WEST SUSSEX COUNTY COUNCIL CONSULTATION

TO:	Arun District Council FAO: Maria Tomalova
FROM:	WSCC - Highways Authority
DATE:	17 May 2022
LOCATION:	Rear of 42 Sudley Road Bognor Regis PO21 1ES
SUBJECT:	BR/77/22/PL 2 No. semi-detached 3-storey houses with parking and new vehicular access. This application is in CIL Zone 4 and is CIL liable as new dwellings.
DATE OF SITE VISIT:	n/a
RECOMMENDATION:	Advice
S106 CONTRIBUTION TOTAL:	n/a

SITE PLAN - 1/500

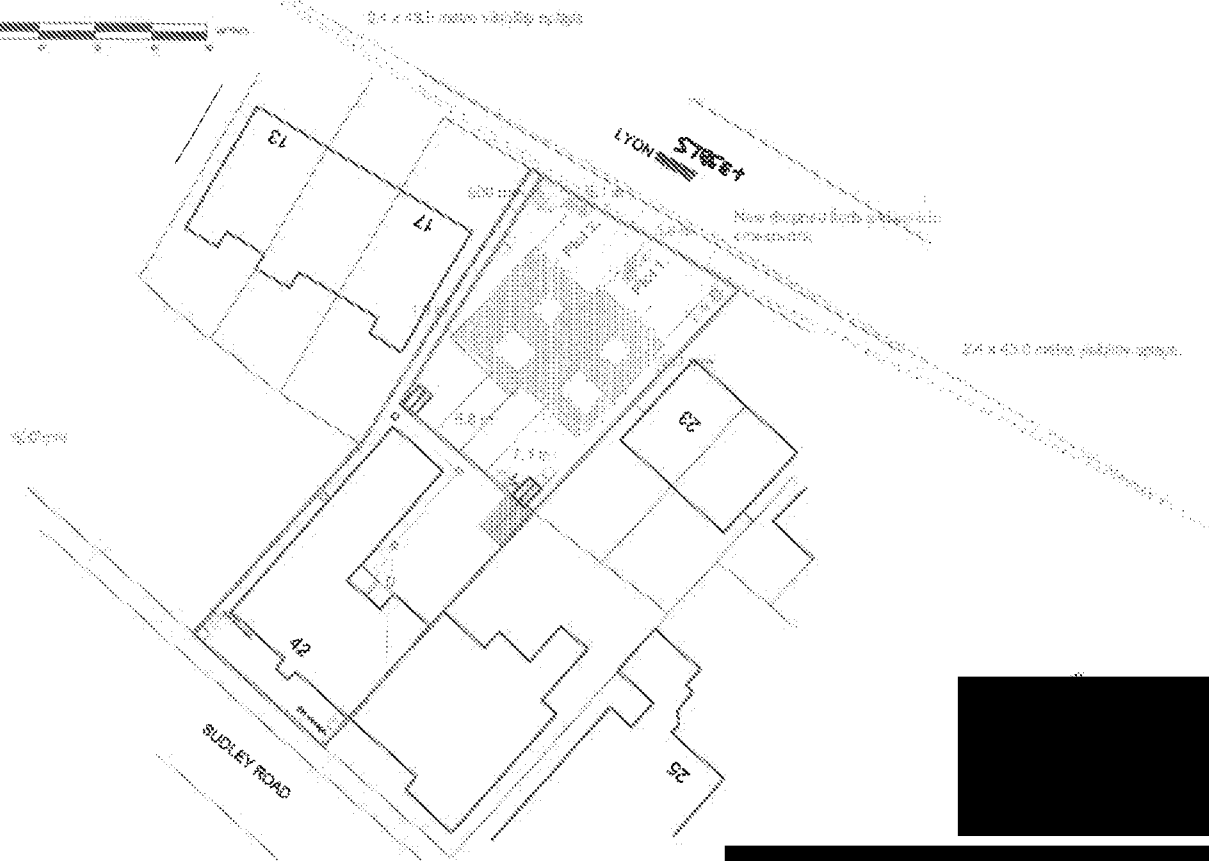
The proposed accesses will be located on Lyon Street, an un-classified road subject to a speed limit of 30mph. Local mapping indicates that an existing access currently exists to the site, however this will not be utilised for the proposal and has not been demonstrated on the proposed plans. The applicant should be aware that the proposed accesses are unlikely to be granted a licence in the event that the existing access is not closed off. As such the applicant is advised to demonstrate that the existing access will be closed off. Details of this can be secured via condition, or alternatively can be resolved prior to determination.

From an inspection of local mapping, it appears that the existing CPZ road sign and telegraph poles located on public highway fronting the site will be required to be relocated due to the proposed crossover works. This has not been demonstrated on the proposed plans. These relocation works would need to be undertaken at the expense of the applicant. It is the responsibility of the applicant to liaise with the necessary parties to organise the moving of the street lighting/telecommunications pole. The poles will need to be relocated at least 1.5m from the location of the top of the ramped kerb of the proposed crossover.

The proposed plans demonstrate one parking space per dwelling on the site frontage. These spaces appear to meet the minimum specifications of 2.4 x 4.8m as set out in Manual for Streets. The Arun Parking SPD expects that a minimum of 2 parking spaces per dwelling would be required for dwellings of this size and location. As such, the proposal may result in the potential for two additional overspill parking spaces to be accommodated on street. Whilst on-street car parking is limited in the immediate vicinity there are comprehensive parking restrictions prohibiting vehicles from parking in places that would be detrimental to highway safety. We would not consider that highway safety would be detrimentally affected through the proposed car parking provision. However, the Planning Authority may wish to consider the potential impacts of this development on on-street car parking from an amenity point of view and consider the existing waiting list length for parking permits in this area.
